From: Mark Warwick <Mark.Warwick@arun.gov.uk>
Sent: 13 January 2020 14:41
To: James Cross <James.Cross@arun.gov.uk>
Cc: [REDACTED]
Subject: FW: LLD1762 - Langford Tree Protection Plan (update)

Planning Officer: James Cross

Planning Application Ref: CM/64/19/PL

Location: Langford, Horsemere Green Lane, Climping, BN17 5QZ

Tree Retention and Protection Plan
Langford, Horsemere Green Lane, Clymping

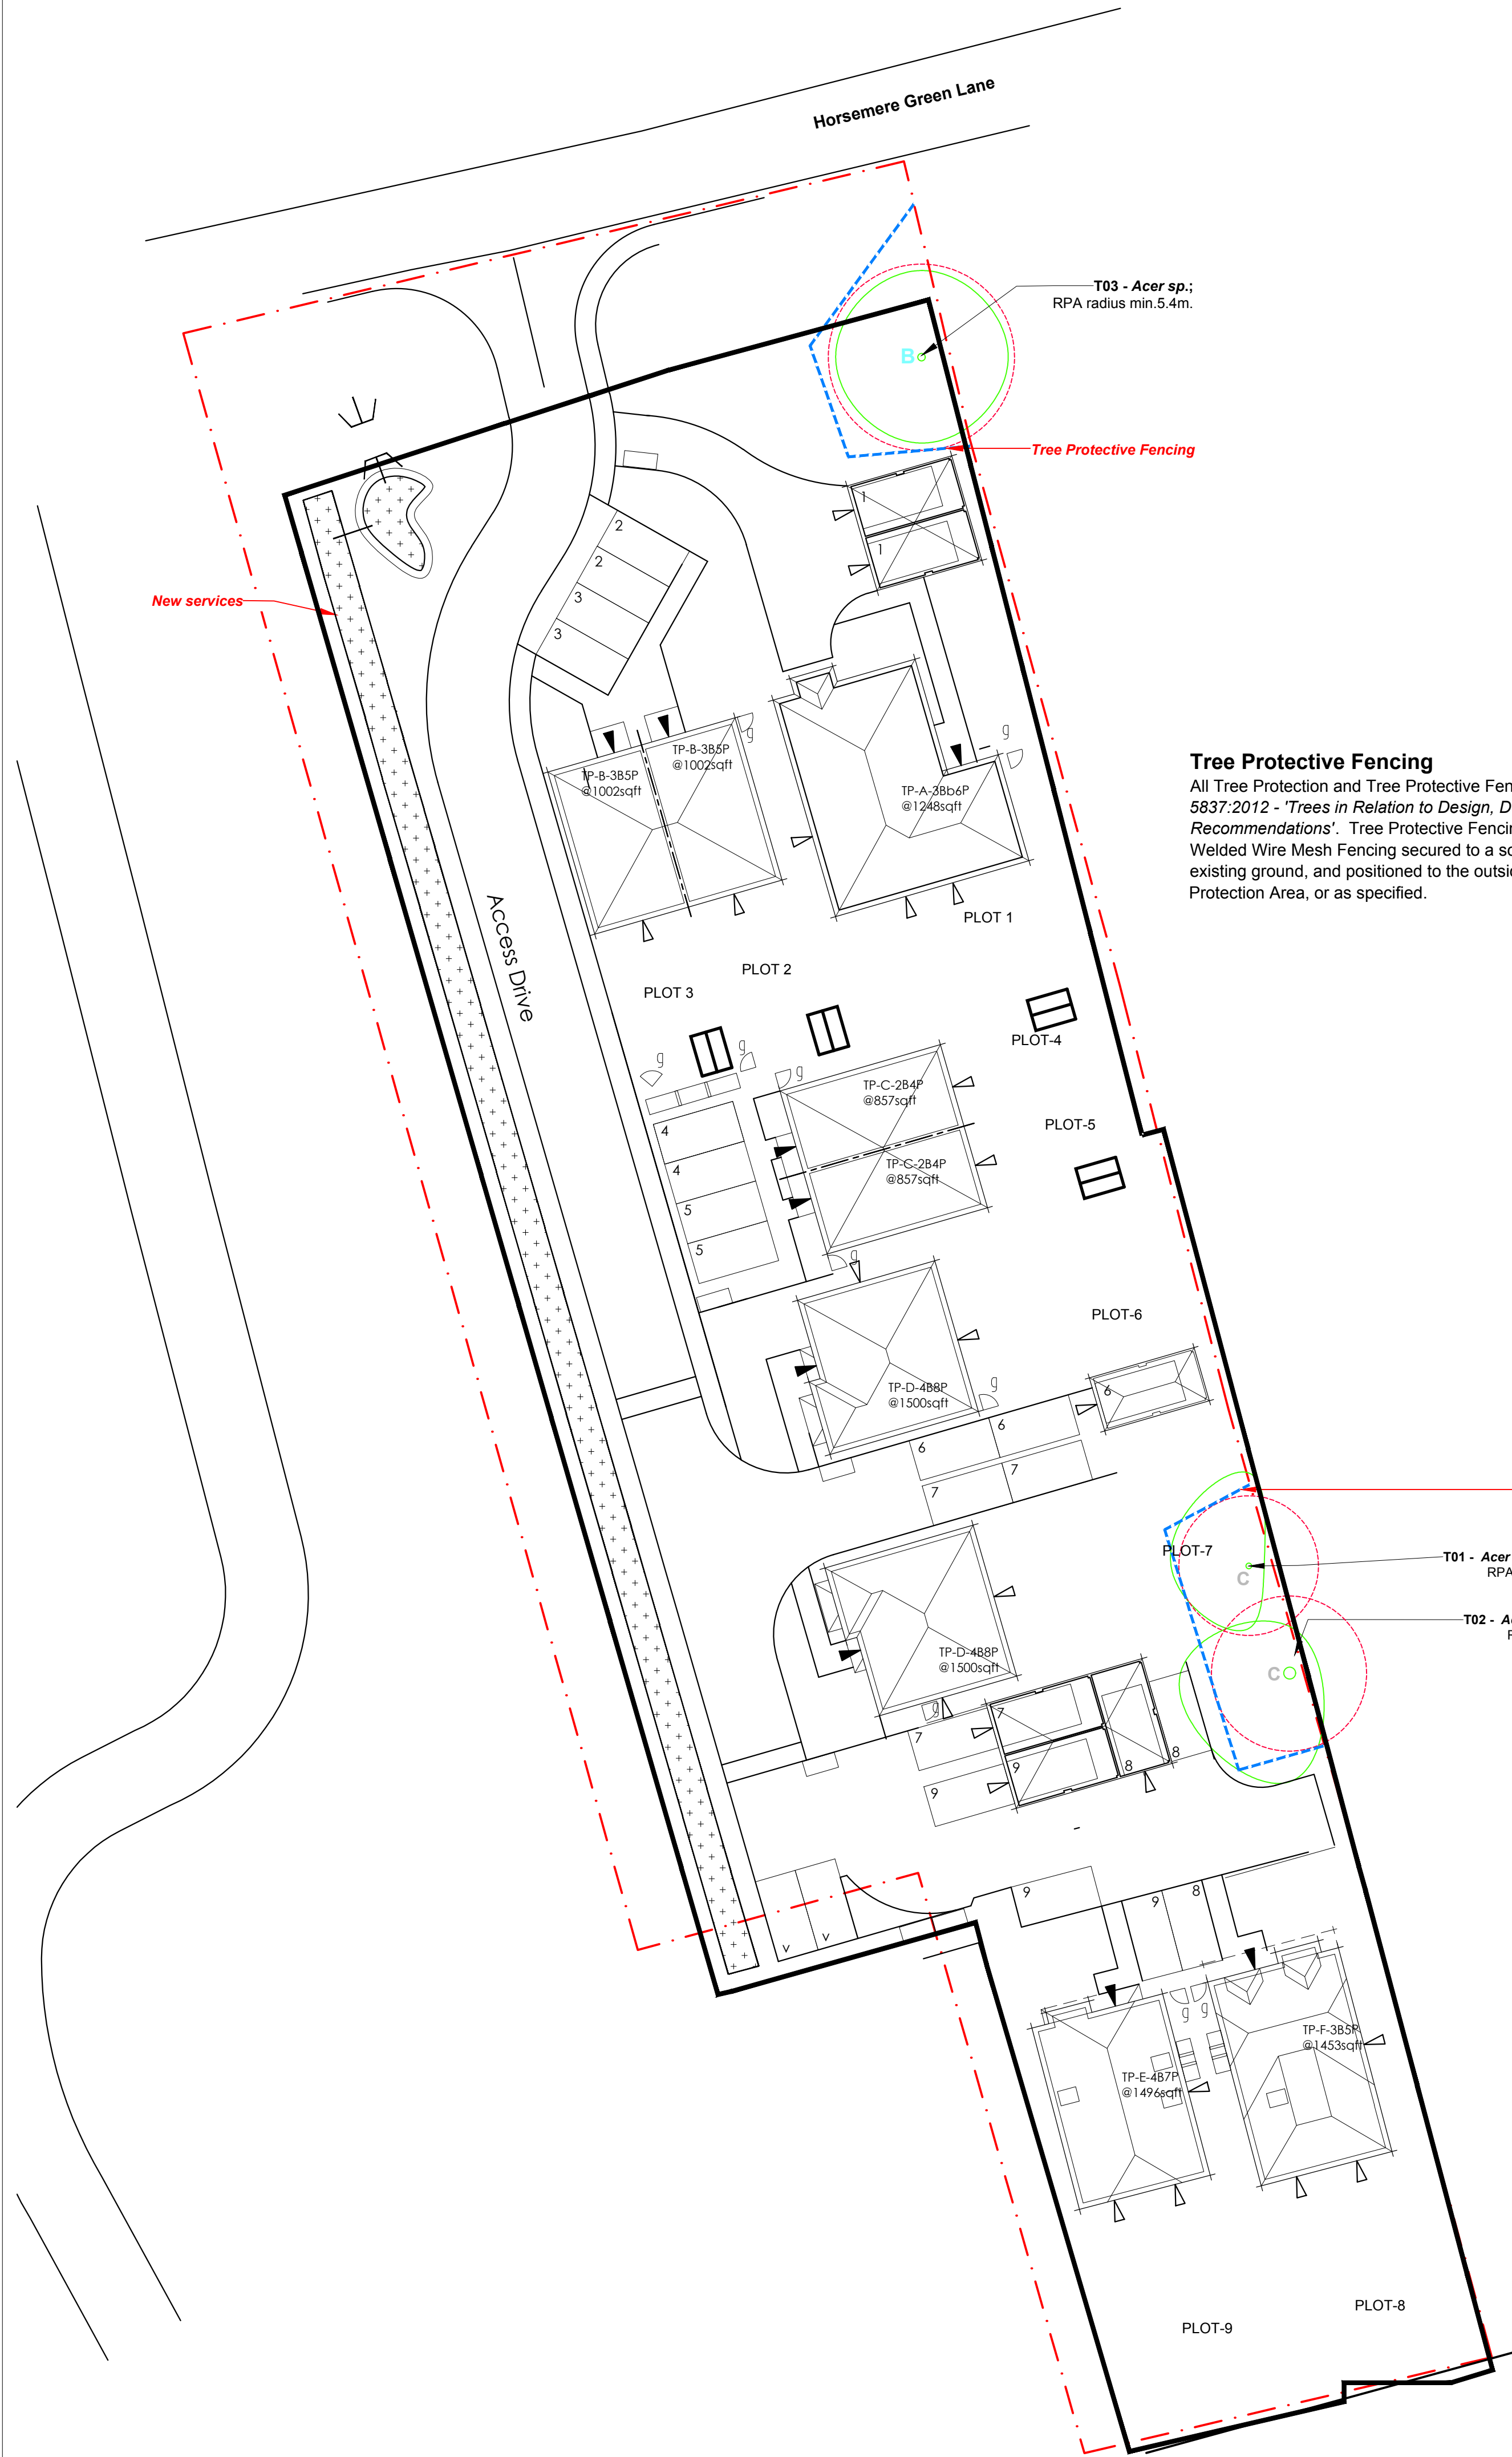
- With so few trees remaining across the site, there are few opportunities for conflict between trees and any construction. Those trees to be retained have been afforded sufficient room to allow future growth without constraint.

- I recommend the above scheme for **APPROVAL**, subject to the following conditions being applied:
 1. Before the site is occupied or any machinery is introduced to the site or demolition work or construction work or alterations to existing ground levels takes place a **PRE-COMMENCEMENT Site Meeting** is to take place between the Planning Authority's Tree Officer and the Arboricultural Expert representing the site owner(s) – at this meeting all protective fencing and ground protection measures will be inspected to verify they are 'Fit for Purpose' as required under British Standard 5837:2012 and have been erected and positioned exactly as shown on the **Tree Retention and Protection Plan, dwg.no. LLD1762-ARB-DWG-002, Rev 06.**
